Reinforcement to the North Shropshire Electricity Distribution Network

Document Reference: 6.6.7
Environmental Statement Appendix 6.7
LVIA Scoping Opinion Responses

APPENDIX 6.7: LANDSCAPE AND VISUAL ASSESSMENT RESPONSE TO SCOPING OPINION

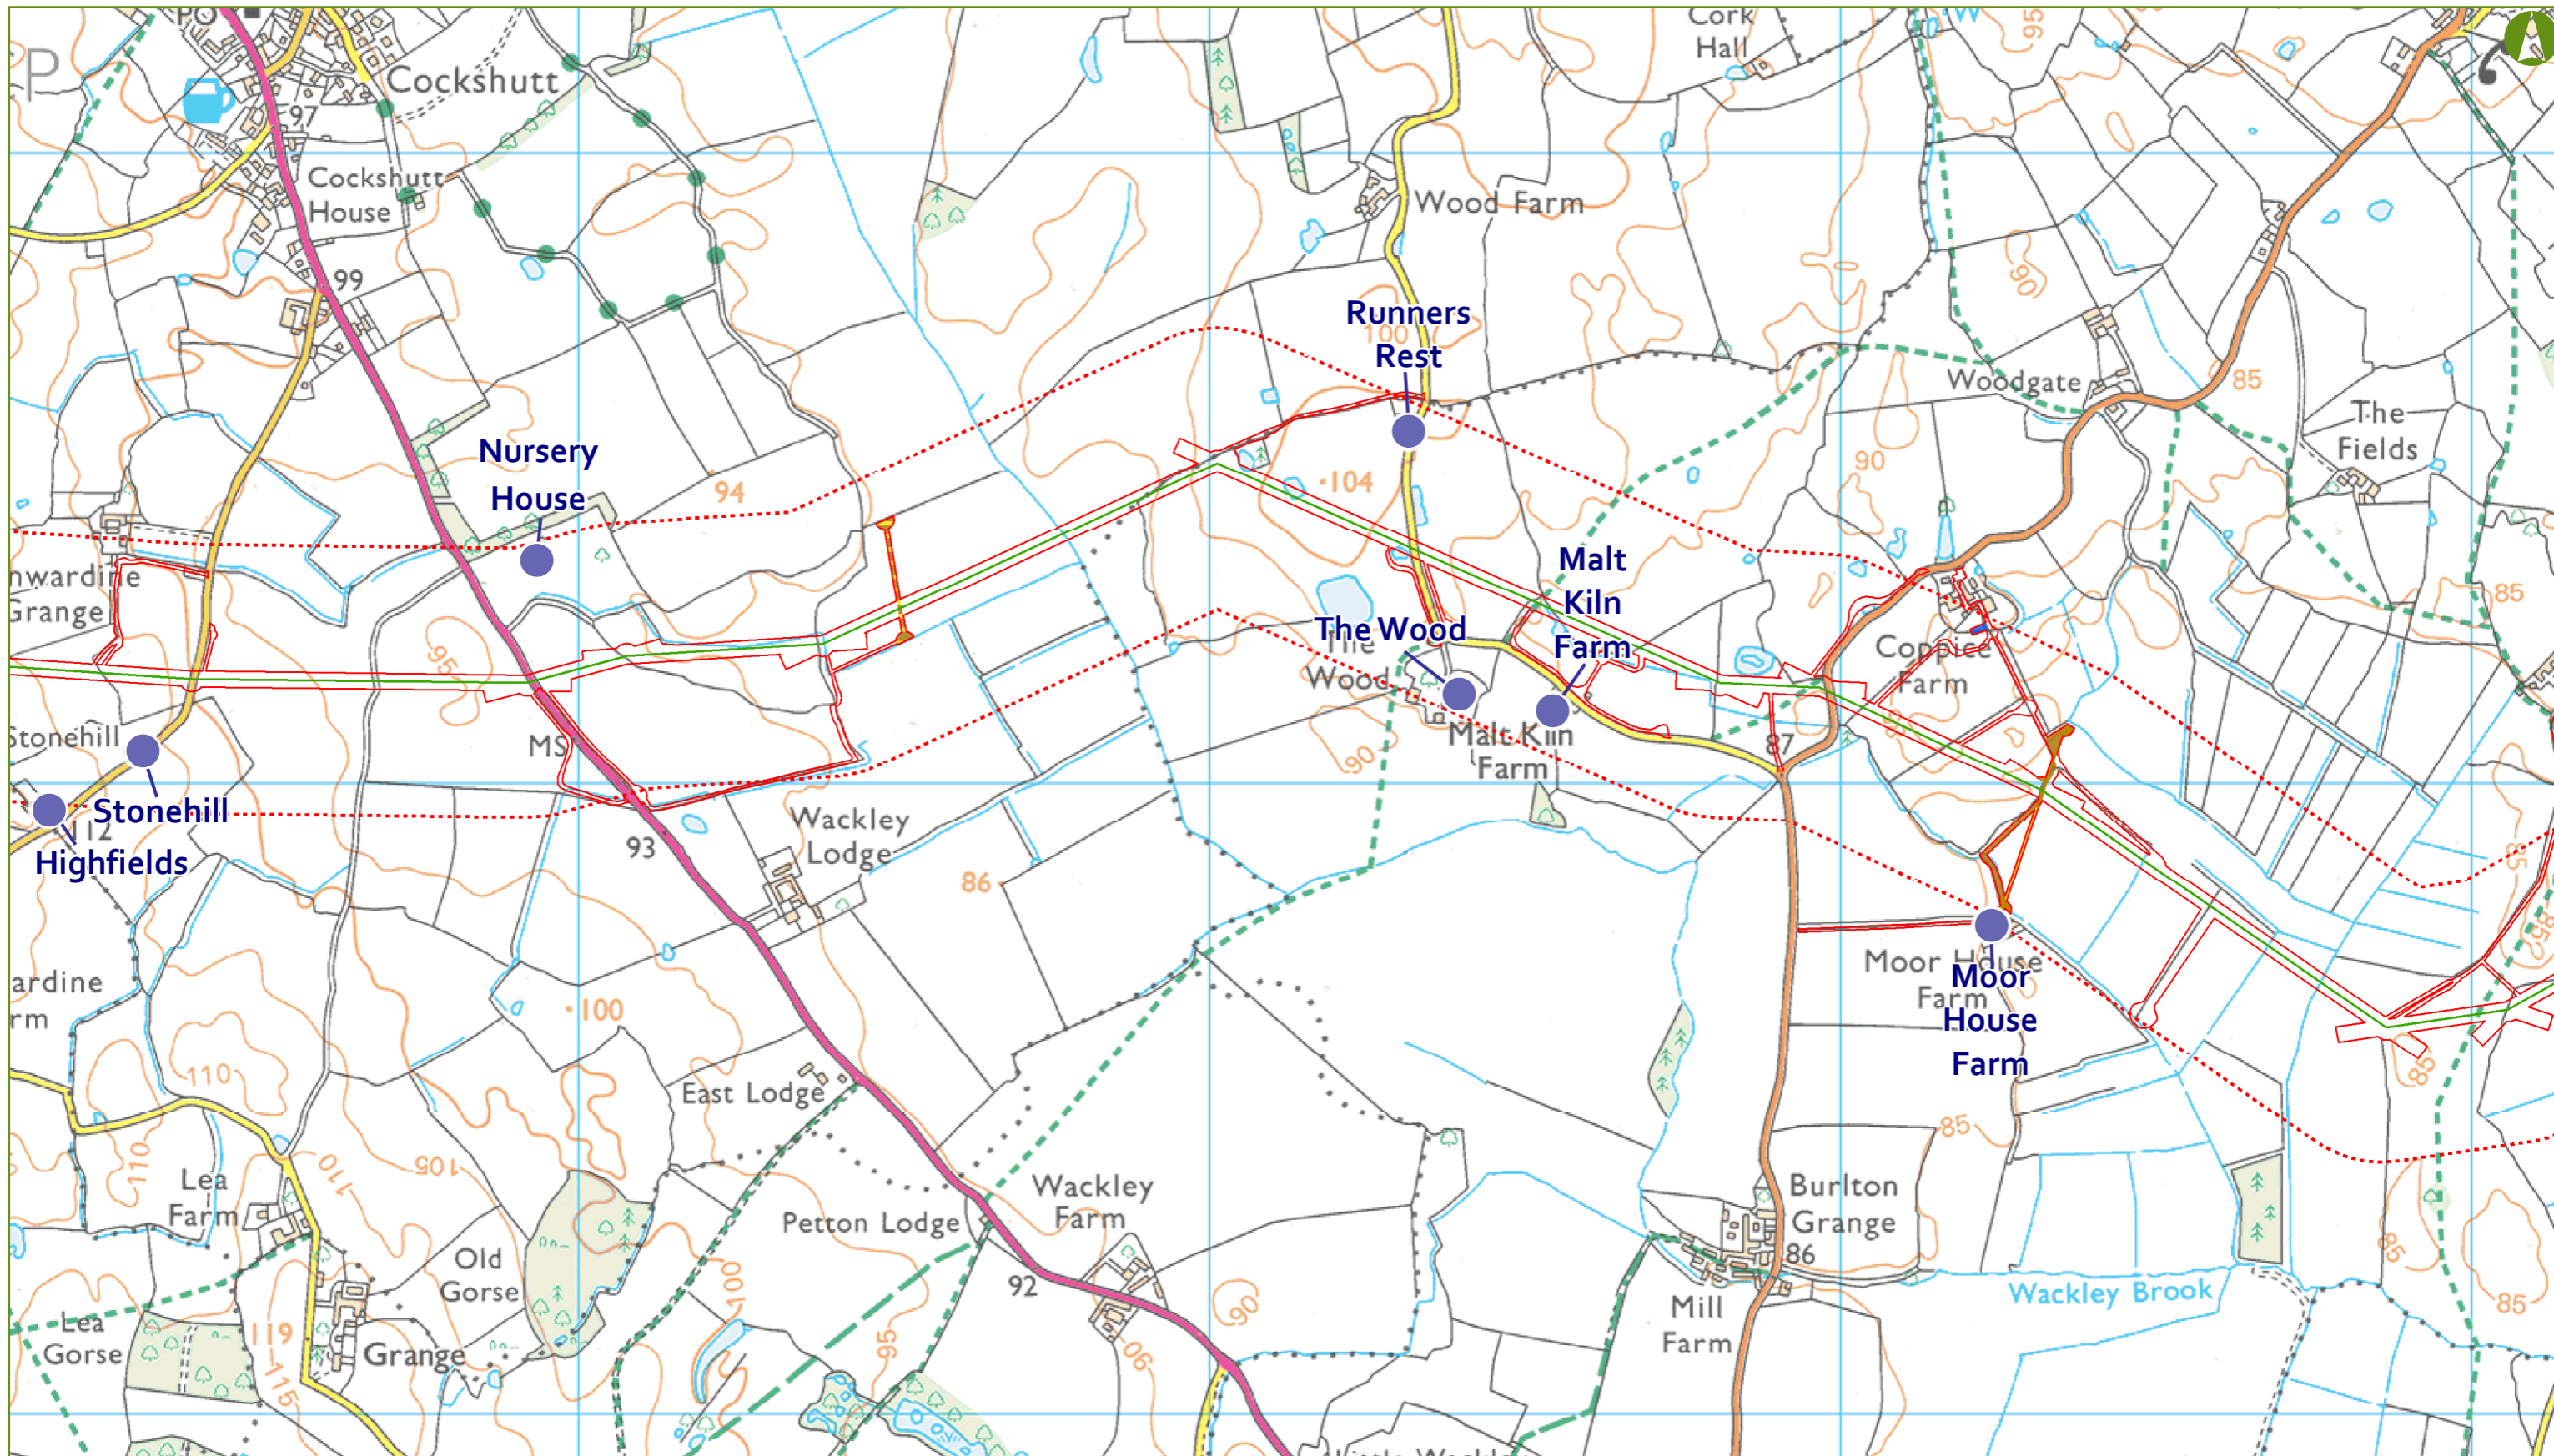
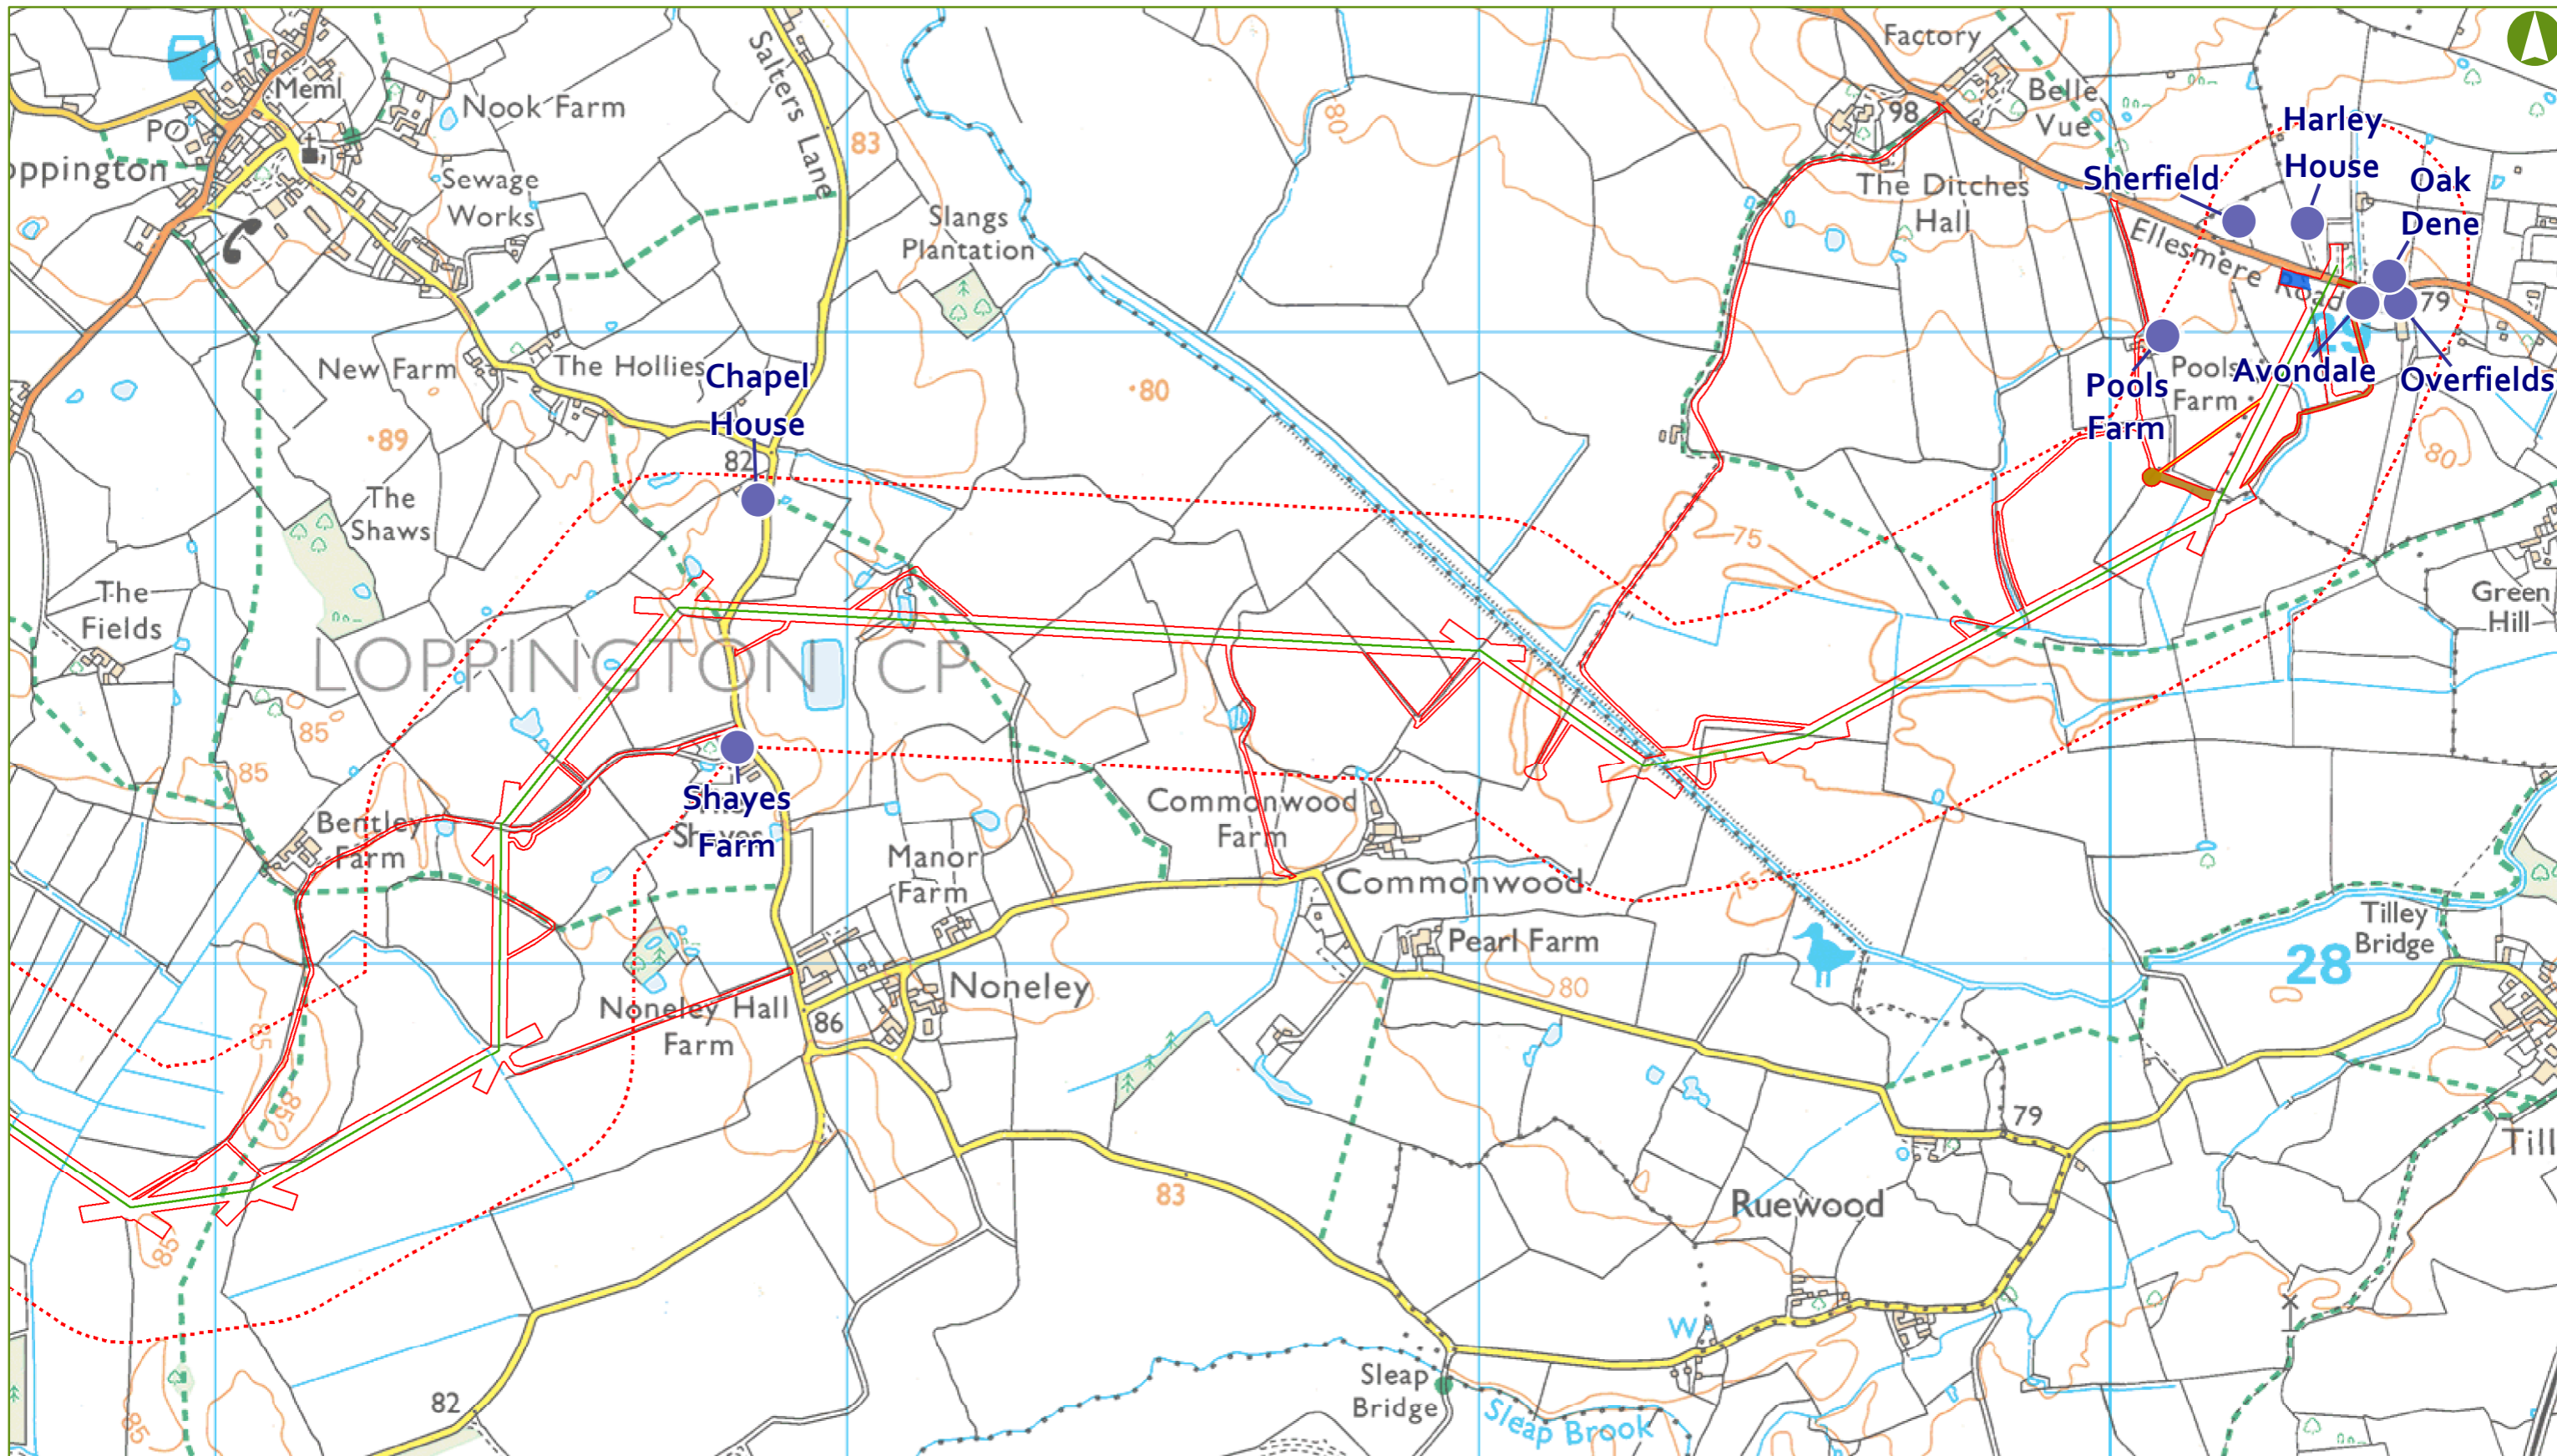
3.47	In addition to the study areas referred to above, paragraph 8.7.24 notes that a residential amenity assessment will be undertaken with a 200m study area either side of the overhead line. The study area should extend from the limits of deviation of the route corridor. This study area does not appear to be depicted on a plan. Such a plan would assist the reader, and it would also be helpful if the selected viewpoints were depicted, especially where particular exceptions have been made and the study area broadened.	The study areas do extend from the Order Limits and are all presented on Figure 6.1 ‘LVIA Study Areas’ (DCO Document 6.14). All viewpoints are presented on Figure 6.8 ‘Viewpoint Locations’ (DCO Document 6.14) and also on Figure 6.5 ‘Topography – Elevation’ (DCO Document 6.14).
